City of Portland, Maine - Building or Use Permit Application
 389 Congress Street, 04101 Tel: (207) 874-8703, Fax: (207) 874-8716

Permit No: 05-1725	Issue Date:	CBL: 370 A020001
------------------------------	--------------------	----------------------------

Past Use: Single Family	Proposed Use: Single Family Wheel Chair ramp	Permit Fee: \$30.00	Cost of Work: \$1,000.00	CEO District: 5
Proposed Project Description: Wheel Chair ramp		FIRE DEPT: <input type="checkbox"/> Approved <input type="checkbox"/> Denied	INSPECTION: Use Group: Type	
		Signature:	Signature:	
PEDESTRIAN ACTIVITIES DISTRICT (P.A.D.)				
Action: <input type="checkbox"/> Approved <input type="checkbox"/> Approved w/Condition <input type="checkbox"/> Denied				
Signature: _____ Date: _____

Dept: Zoning	Status: Approved with Conditions	Reviewer: Jeanine Bourke	Approval Date: 12/01/2005
Note:			Ok to Issue: <input checked="" type="checkbox"/>
1) Permit approved with the condition that a Disability Variance will be applied for within 30 days of issuance. Please complete the enclosed forms and return to this office.			
Dept: Building	Status: Approved with Conditions	Reviewer: Jeanine Bourke	Approval Date: 12/01/2005
N

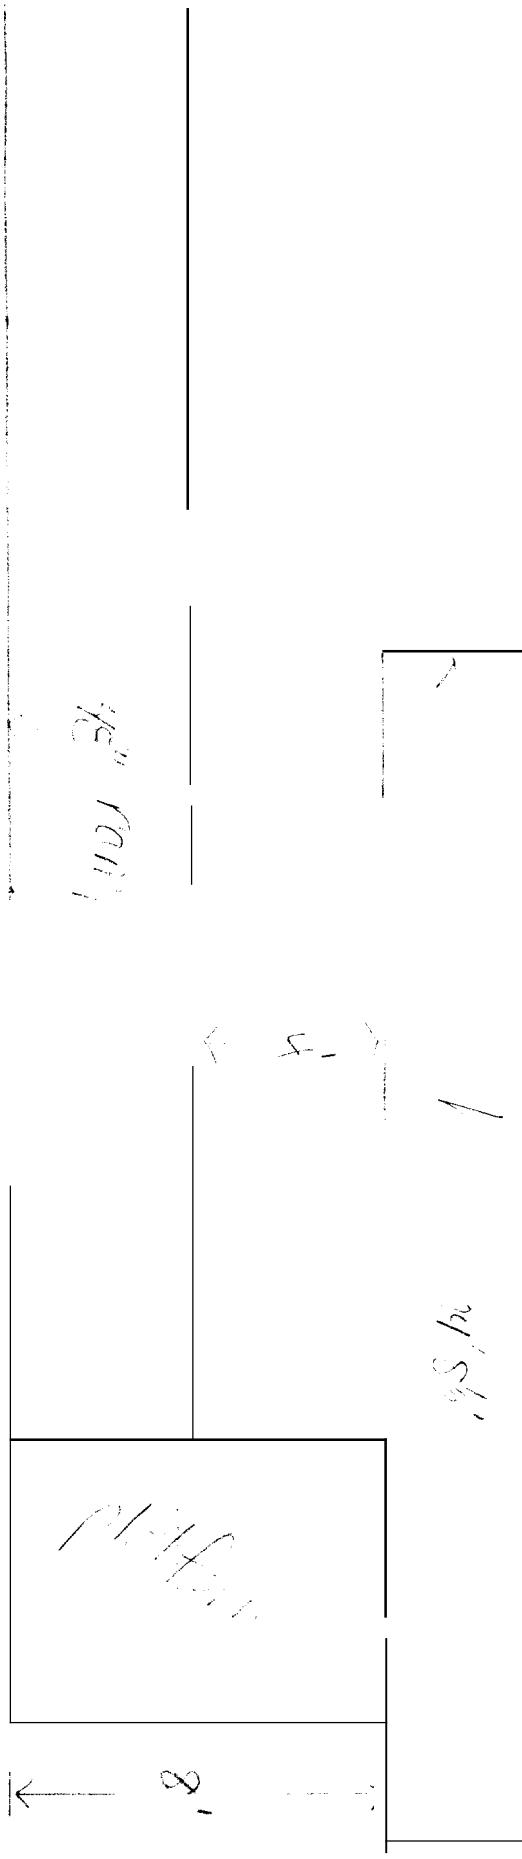
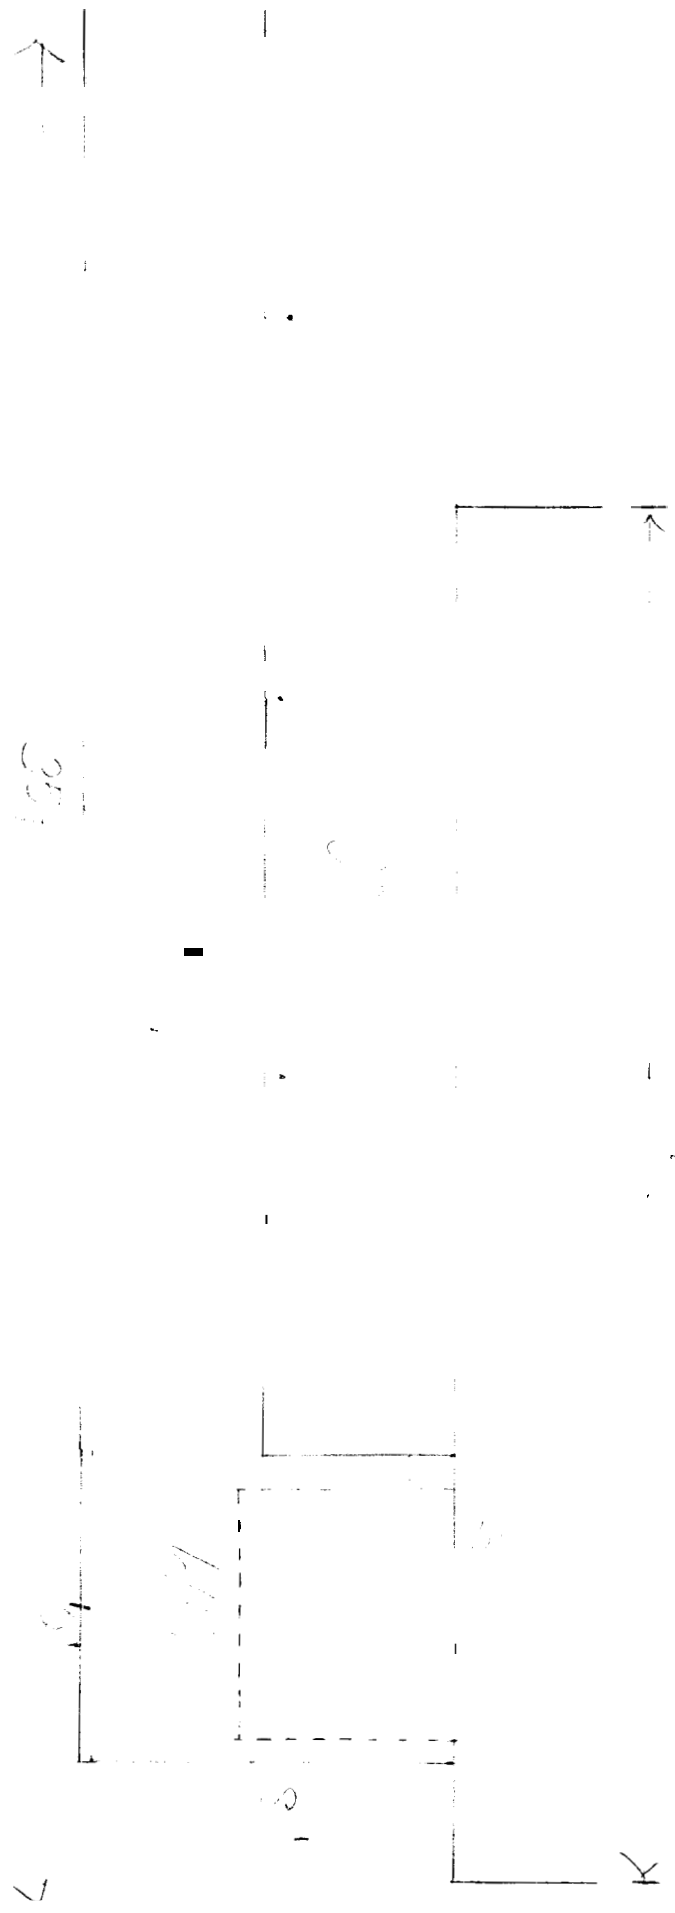
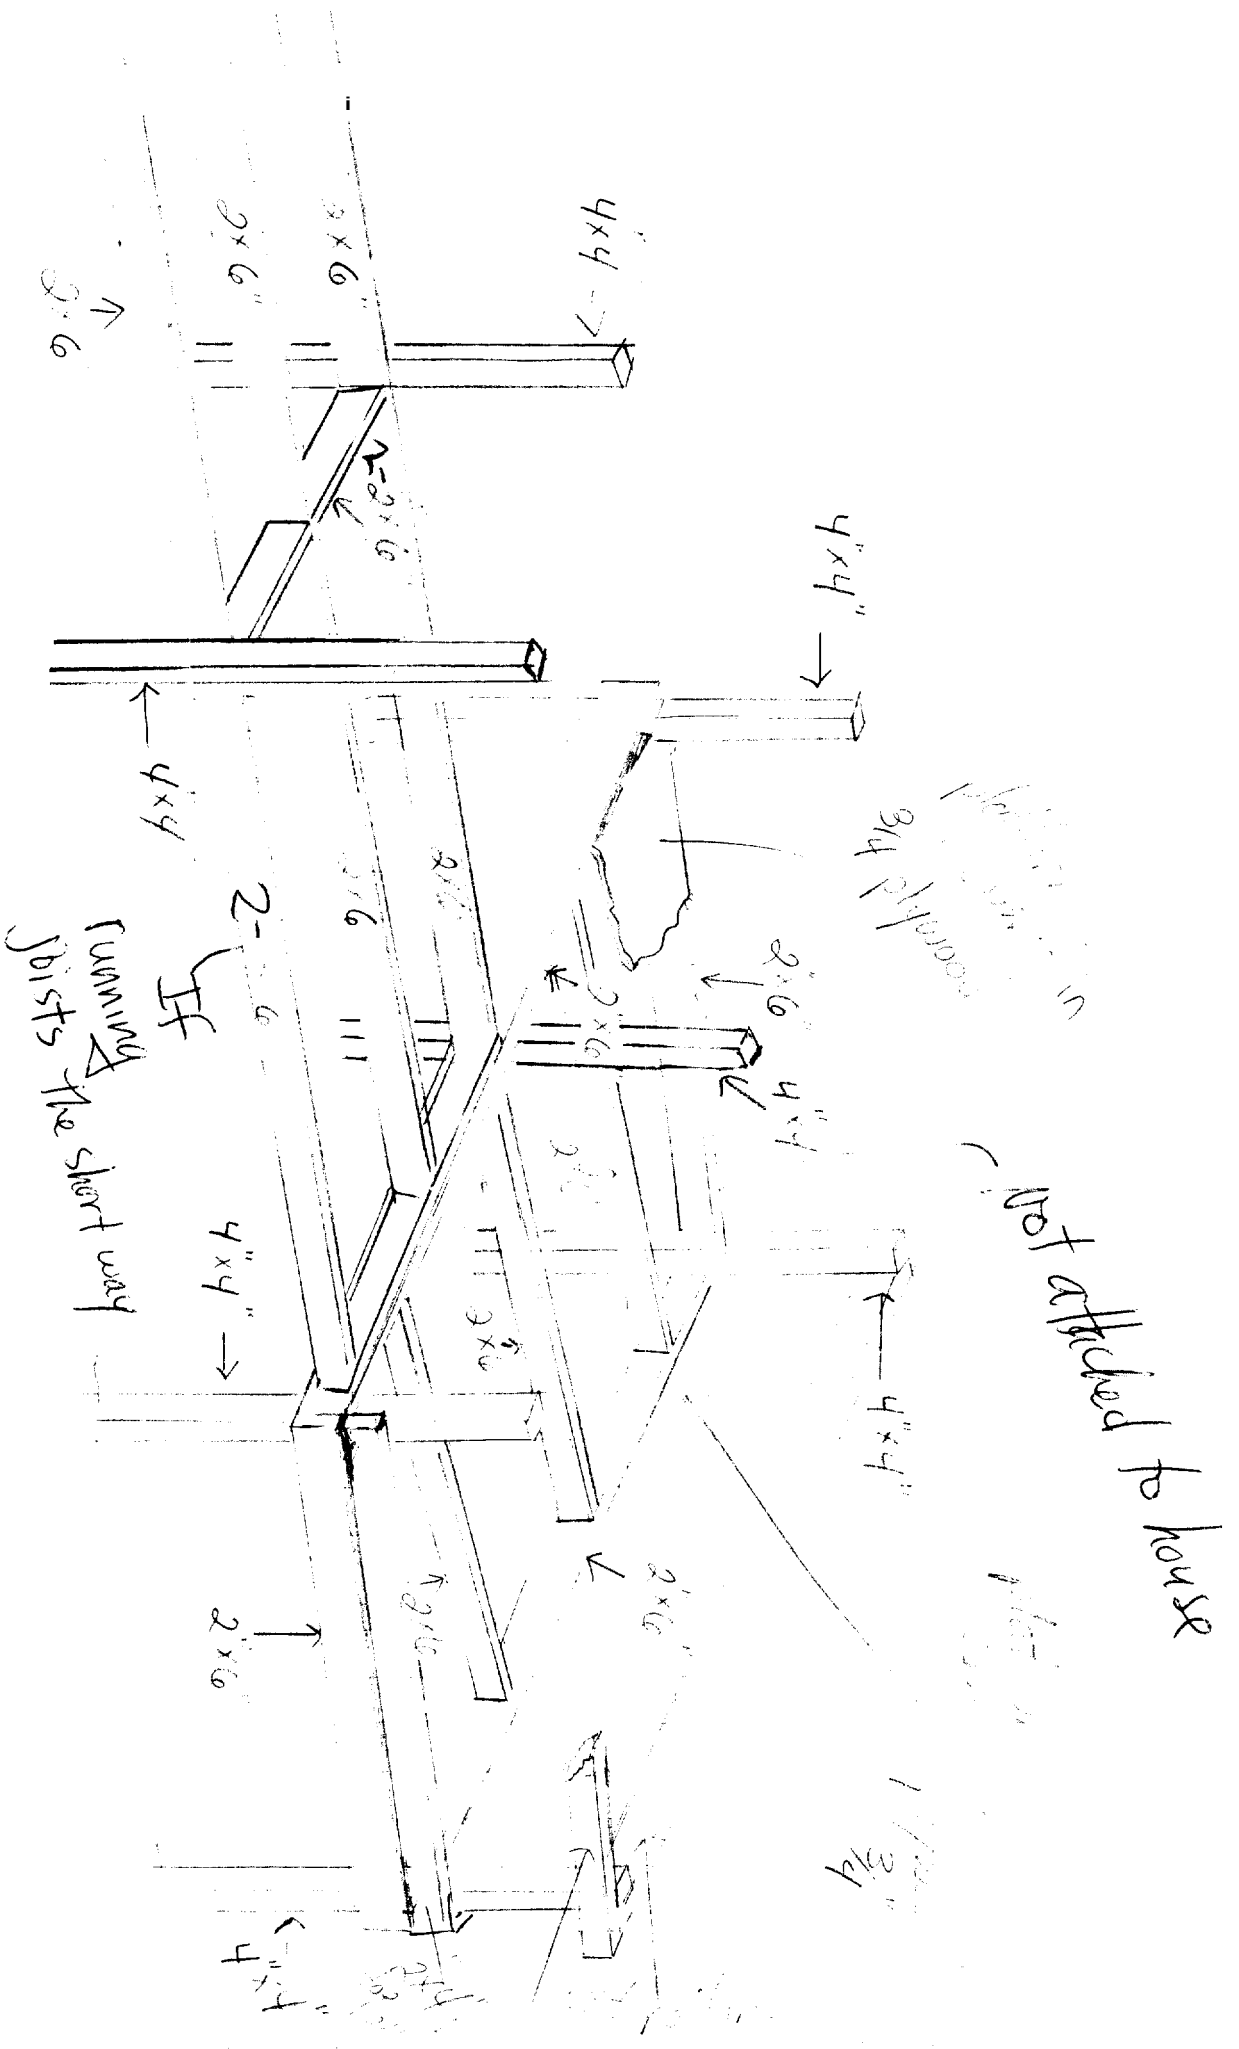
Comments: 11/30/2005-jmb: Left msg. W/Helen for the builders to call for framing details
--
